7-11 Turner Street
Residential Units
Turner Eastern Prom.

**CITY OF PORTLAND, MAINE
DEVELOPMENT REVIEW APPLICATION
PLANNING DEPARTMENT PROCESSING FORM**

Re: 7-11 Turner Street; CBL 014I013; ID#2005-0276

RE: Application for Minor Site Plan, 7 and 11 Turner Street

G1.1

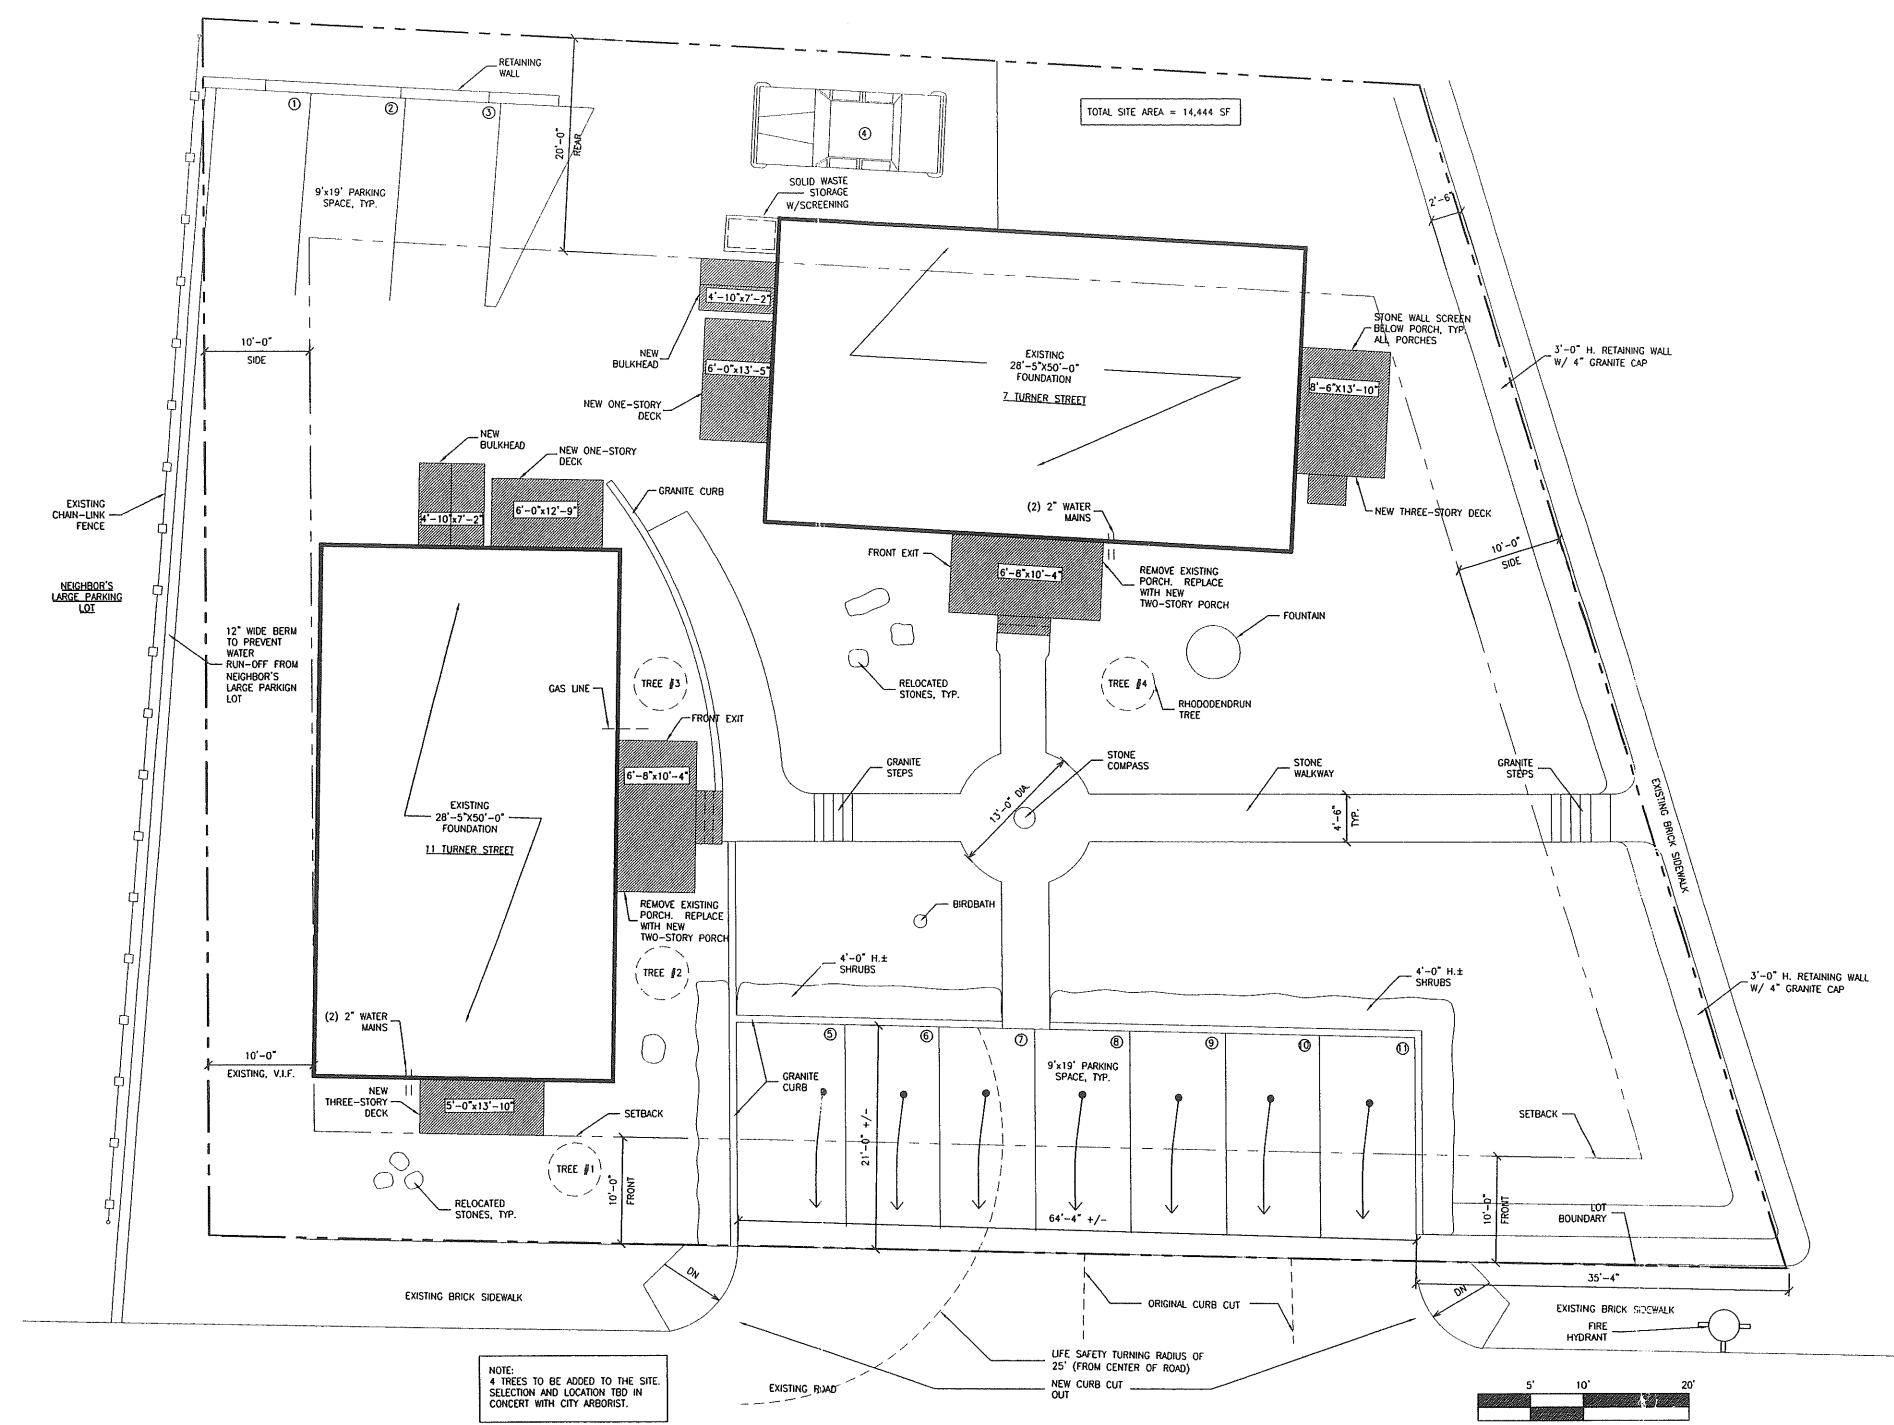
- A. The site has a large paved parking lot. The lot does not contain delineated parking stalls or isles. The parking stalls should be delineated by pavement markings.
- B. The applicant indicates that two parking stalls are located to the southwest of 11 Turner Street. The parking area appears to be outside of the property boundaries of the project.
- C. Curb stops or a wooden guardrail should be installed on the northeast side of the parking lot to eliminate the possibility of vehicles sliding down over the hill onto the sidewalk.

- A. A landscaping plan for the project has not been provided for review.
- B. The existing curb cut for the two parking stalls behind 11 Turner Street should be eliminated and new granite curb installed across the opening and the sidewalk reconstructed.

1. Parking: 12 total spaces are required (9'x19' dimensionally).
 - a. Please show the layout of these spaces in the existing parking area.
 - b. The 2-car driveway encroaches on the abutting property. Please provide any easement information that may exist. If no rights exist, they will need to be removed and 2 additional spaces added elsewhere on the property.

2. The survey and the site plan have different square footage amounts for the lot, please clarify.
3. The proposed 'street trees' are typically planted along the street frontage/property line. Please relocate and add a note of their size and species type.

4. Per-site plan standards, the solid waste storage areas need to be fenced/screened. Please add enclosures/fencing to the site plan.
5. A sewer capacity letter will need to be obtained from the City's wastewater division. Please contact Frank Brancely at 874-8832 to facilitate this.

- 1) Parking Please see the updated site plan for a revised plan to accommodate 12 cars in the existing parking area in front of the buildings. This plan is based on the design offered by the city's traffic engineer.

- 3) Street tress As requested by the City, the owner will be adding four trees to the property, to be selected in concert with the city arborist. I have removed the actual trees from the site plan, as their location has yet to be determined, and added this same note to the plan.

- 4) Solid waste storage enclosure We have added plan for a fence to surround the solid waste storage area, and indicated so on the site plan.
- 5) Sewer capacity letter Per your suggestion, I have been in touch with Franc Brancely at the Department of Public Works and have requested a sewer capacity letter for this property. He is in the process of preparing this letter for us and I understand that the site plan approval will not be held up by this pending letter.
